Application by Highways England for A47 Wansford to Sutton Dualling

The Examining Authority's written questions and requests for information (ExQ1)

Issued on 16 December 2021

ENGINEERING SECTIONS  
CHAINAGE LOCATIONS  
SHEET 4 OF 4

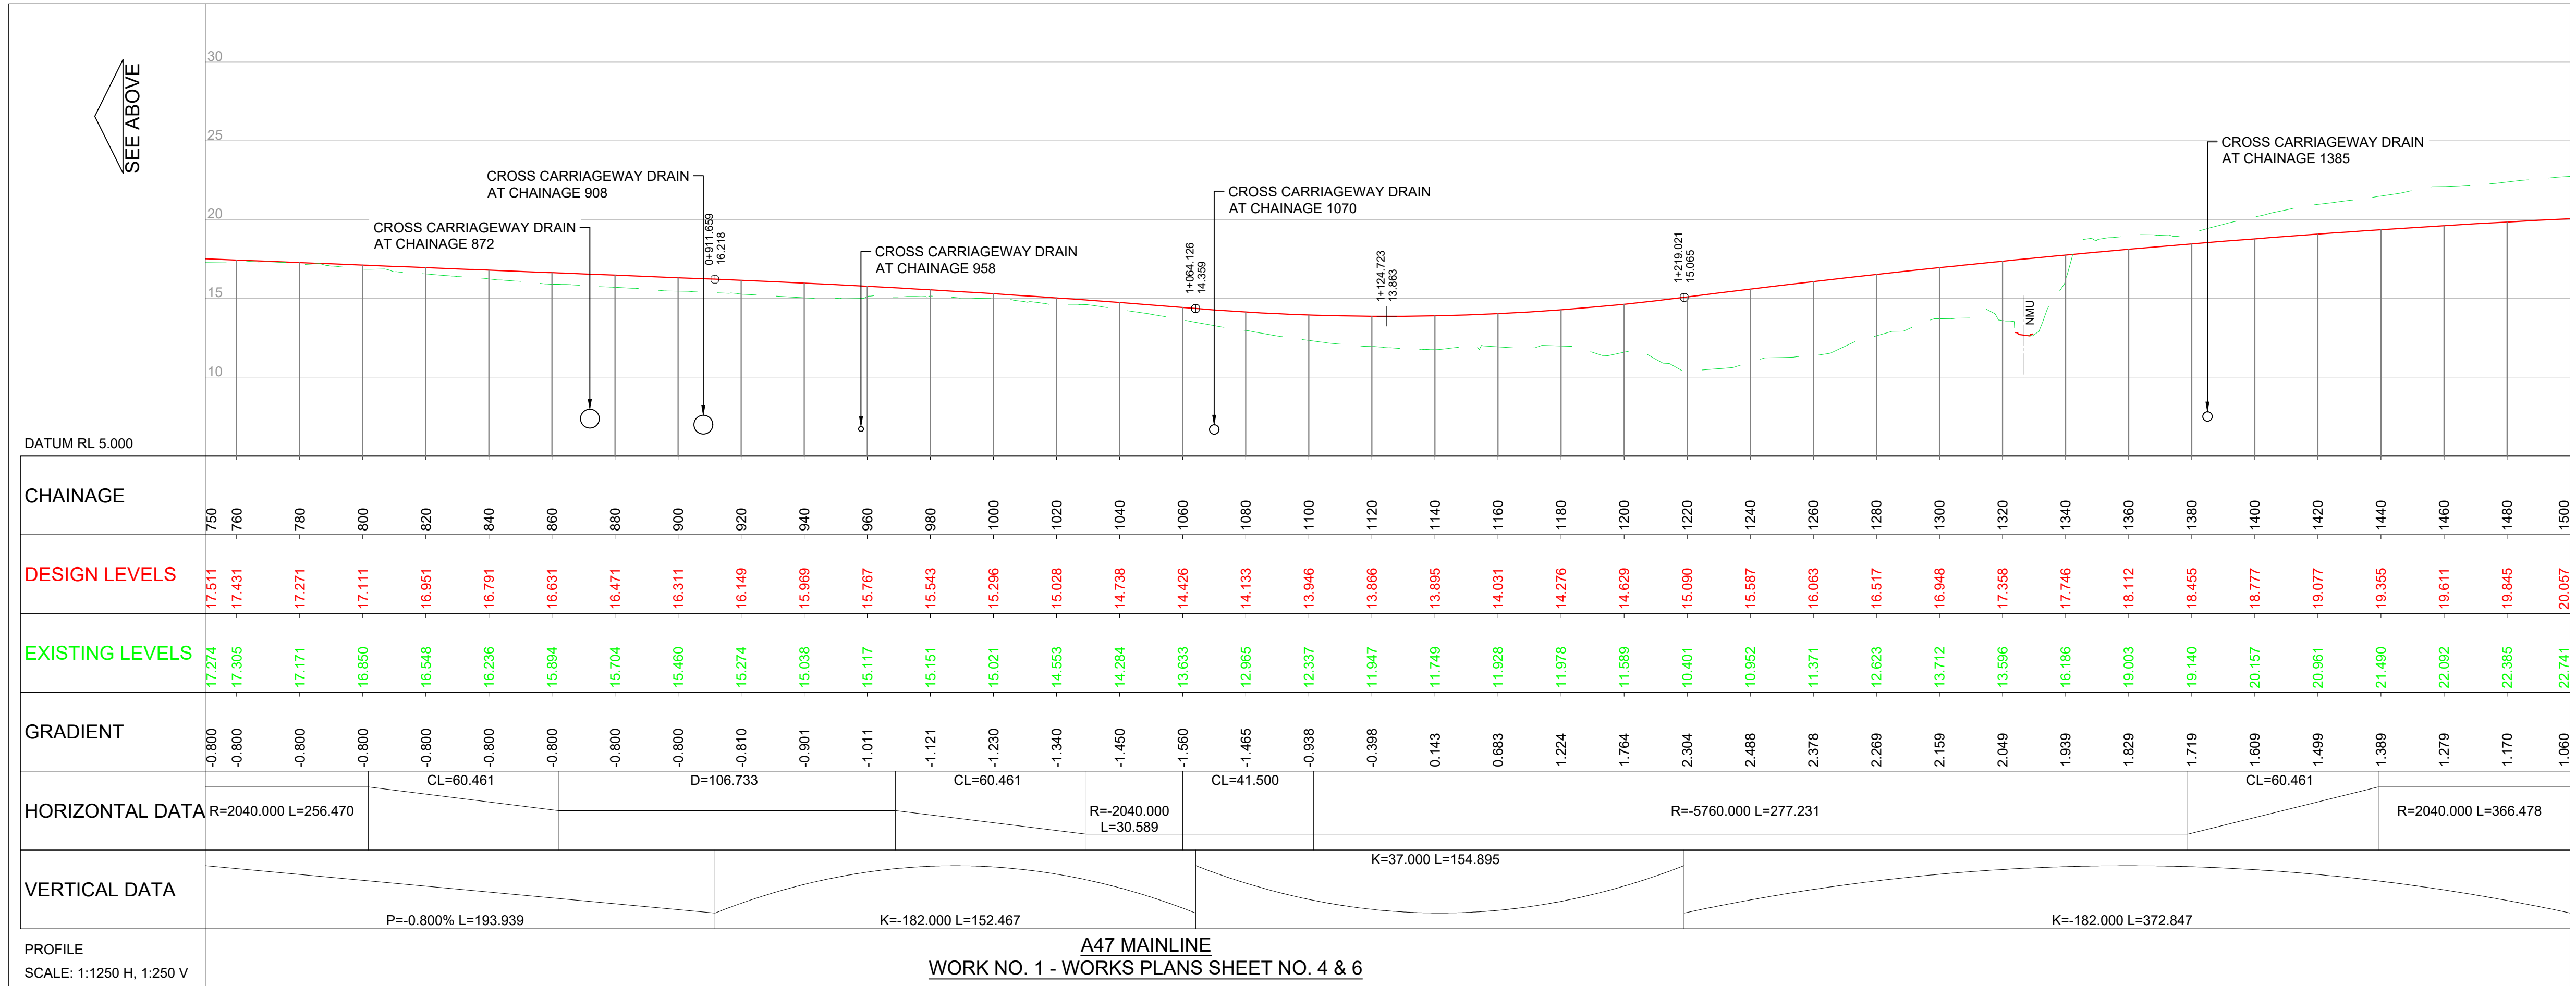
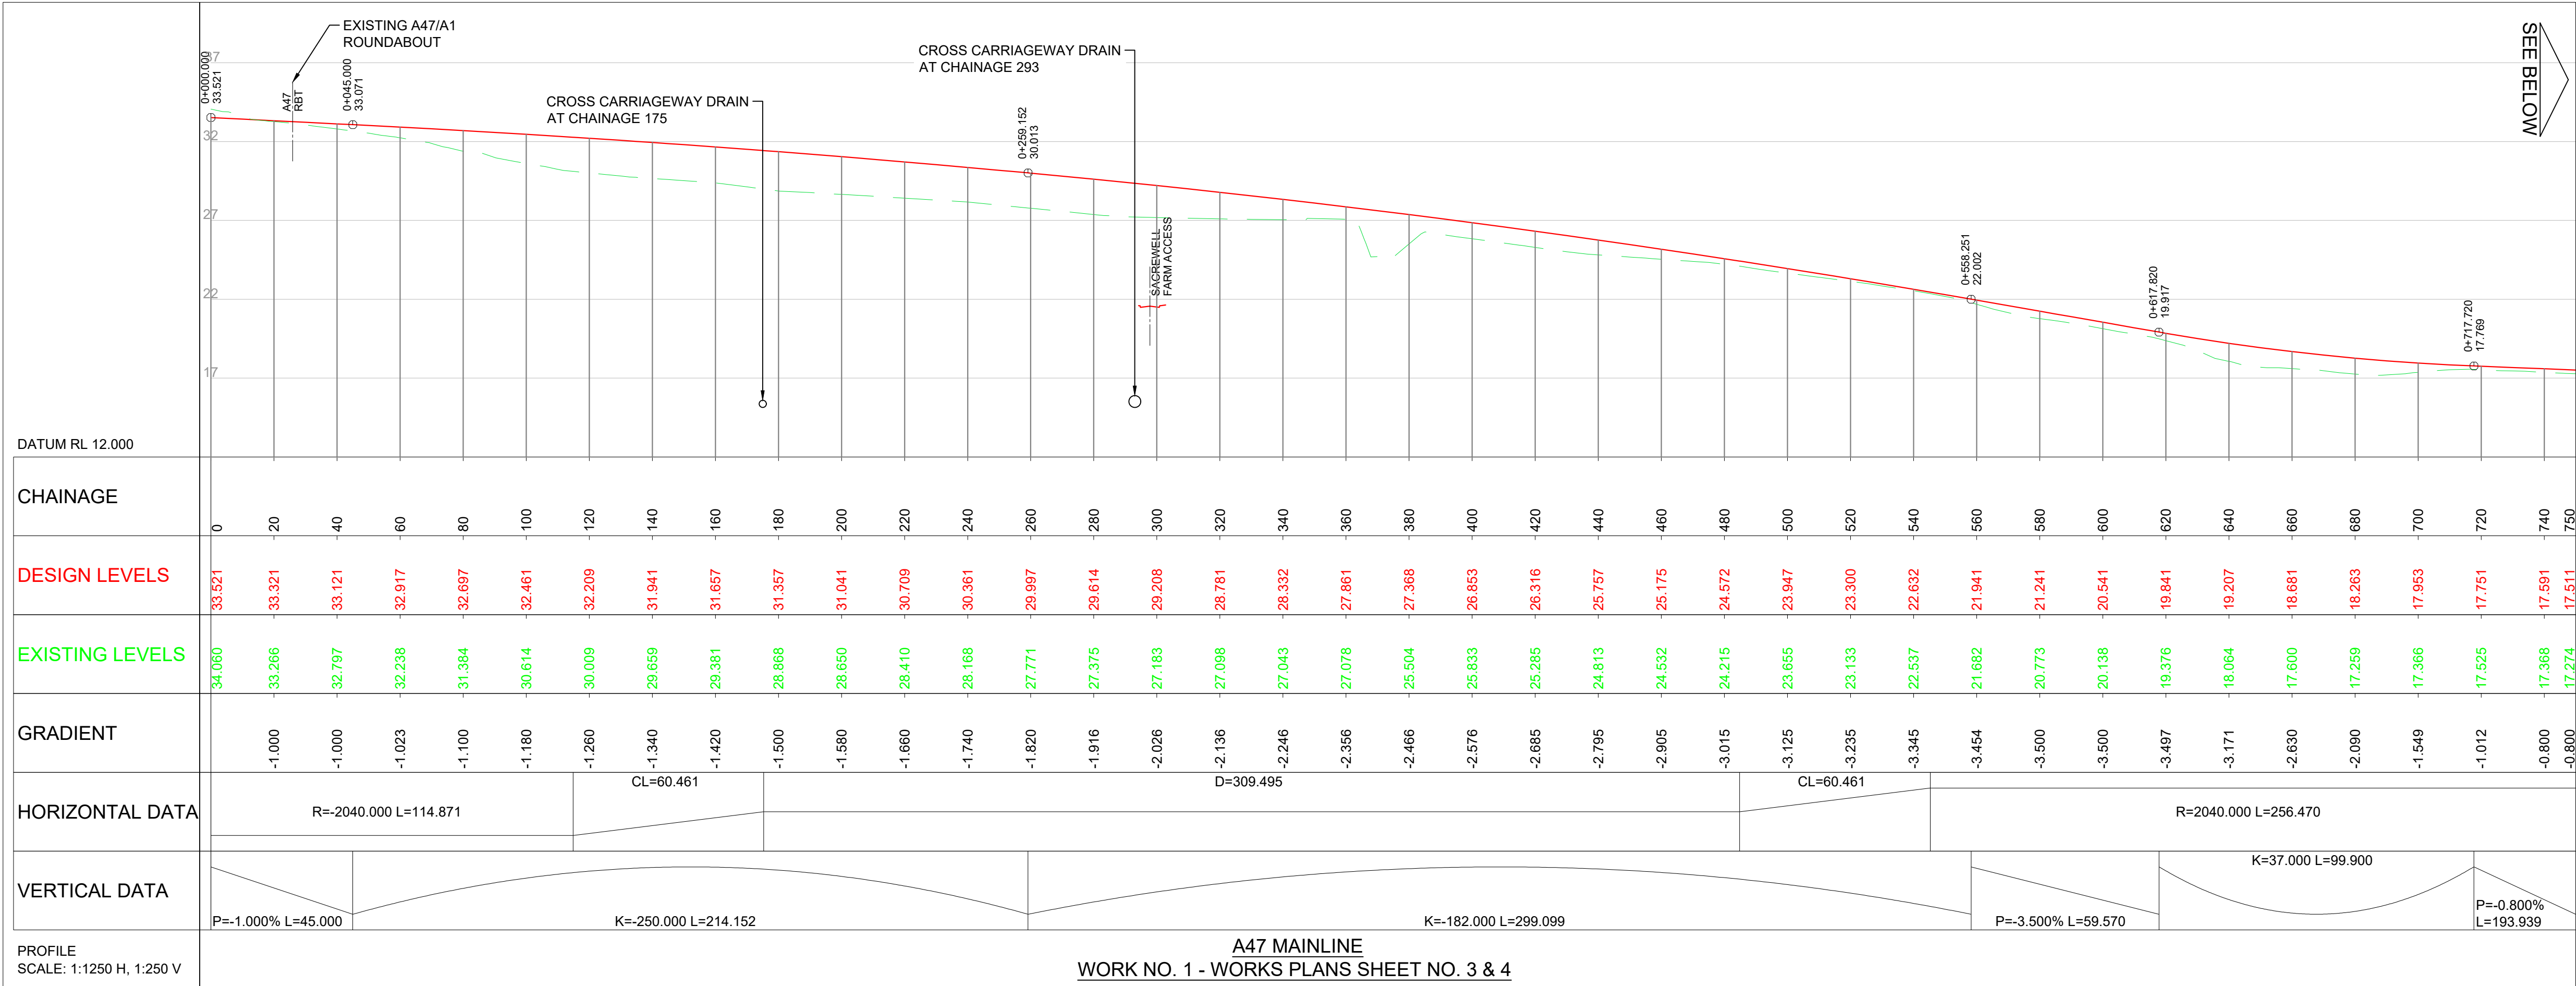
1.0.6.	The Applicant	Engineering Drawings a) Can the Applicant please put chainage markers from the Engineering sections onto a plan showing the proposed works (preferably as additional drawings at the end of the Engineering Sections or as an addition to the Works Plans). Chainages need only be shown every 50m so as to avoid too much information on the drawings. b) Can the location of the sections shown on sheets 4, 5 and 6 of the Engineering drawings also be shown on plans.

DRAWING TITLE <div>ENGINEERING DRAWINGS &amp; SECTIONS (A47 SIDE ROAD CROSS SECTIONS) SACREWELL FARM SHEET 2 OF 3</div>						
SUITABILITY <div>SUITABLE FOR INFORMATION</div>

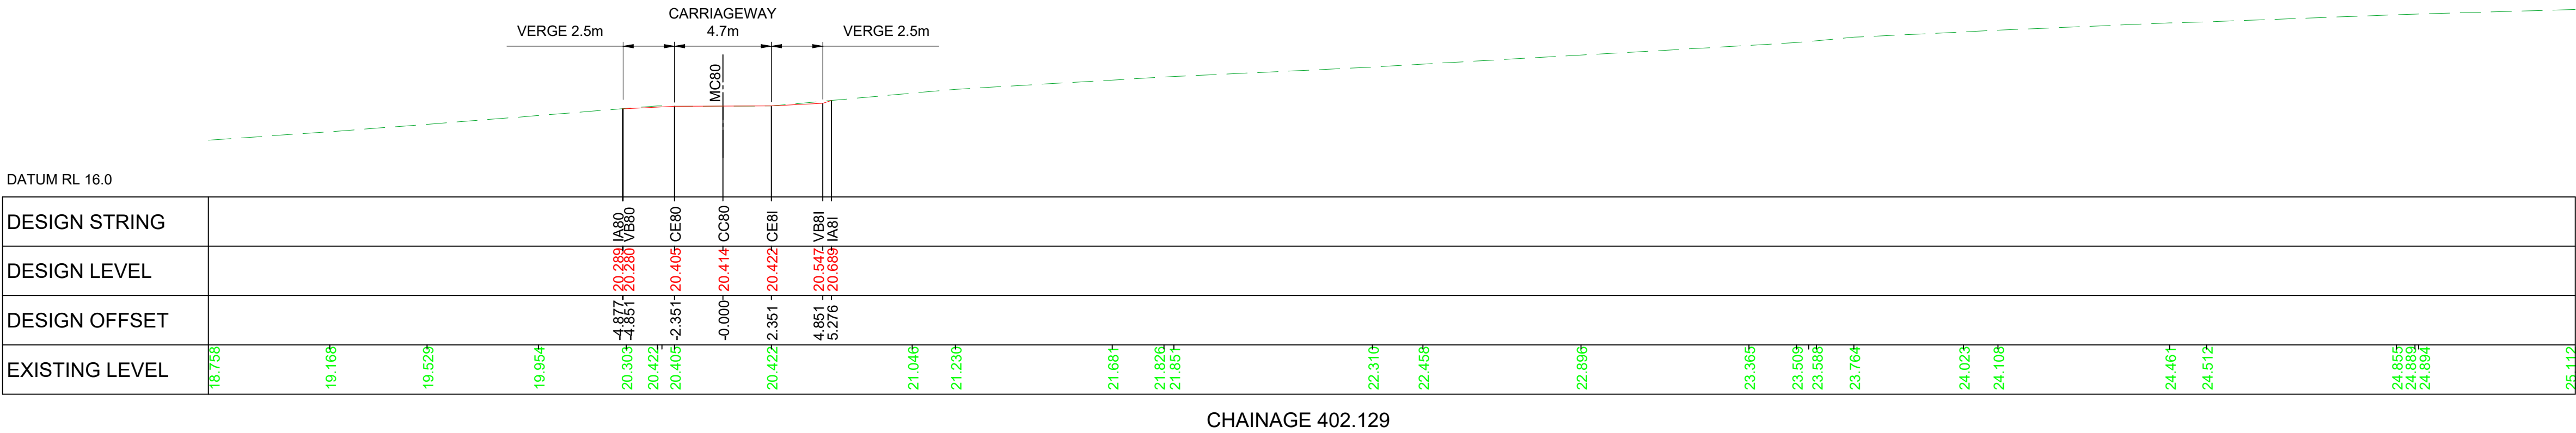
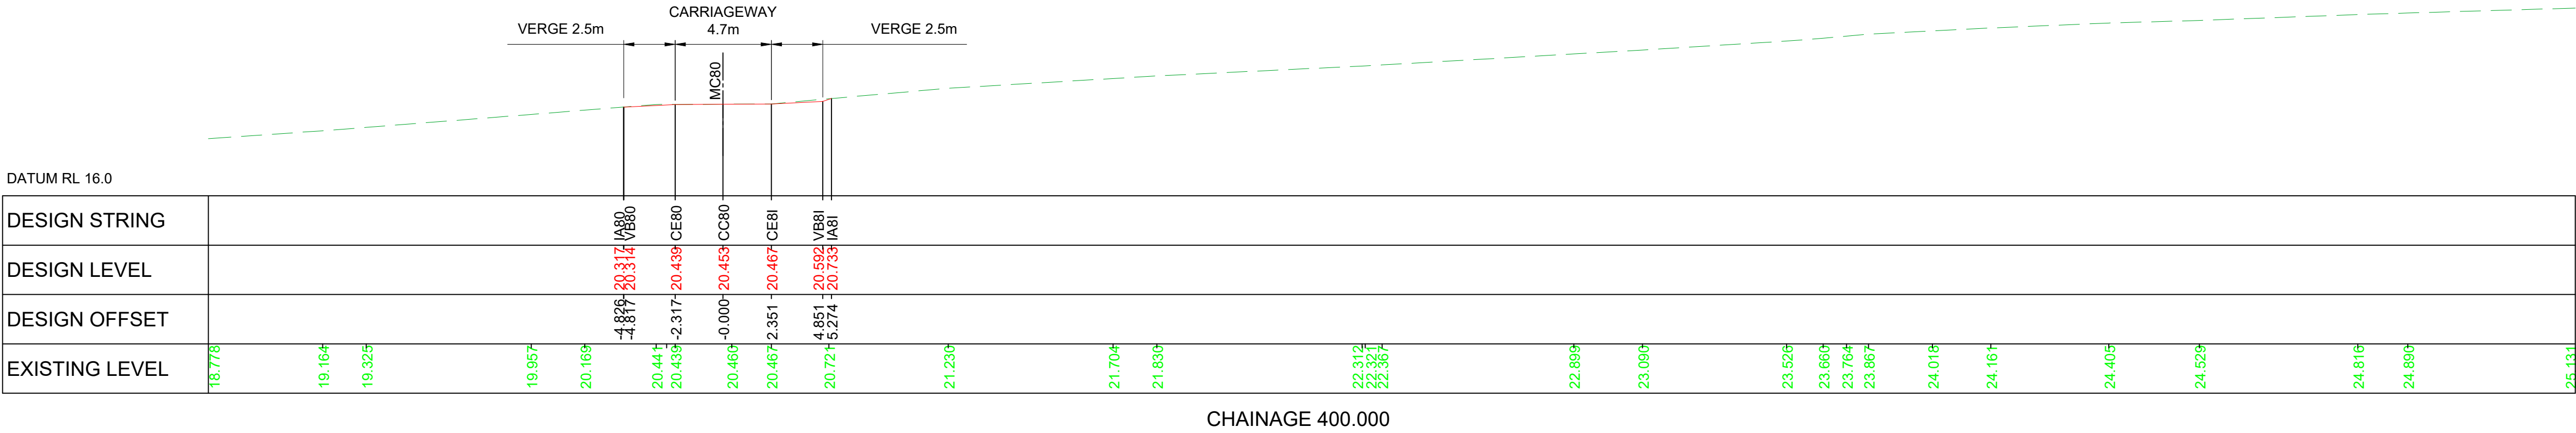
1.0.7.	The Applicant	Engineering Drawings Could sections please be prepared along the line of the proposed Sacrewell Farm entrance private way showing the relationship both along the length and across the width. The length should be, at the south, from the proposed junction with the new link to 10m beyond the tie in at the northern end. There should be at least four cross-sections north of the proposed underbridge, and these should be from at least 10m to the west of the edge of the proposed cutting to 10m to the east of the existing right of way. Could any necessary changes please be made to the extent of the cutting as shown

ExQ1	Question to:	Question:
		on the plans? Given the shape of the existing landform there are doubts as to whether the consistent nature as shown is accurate.
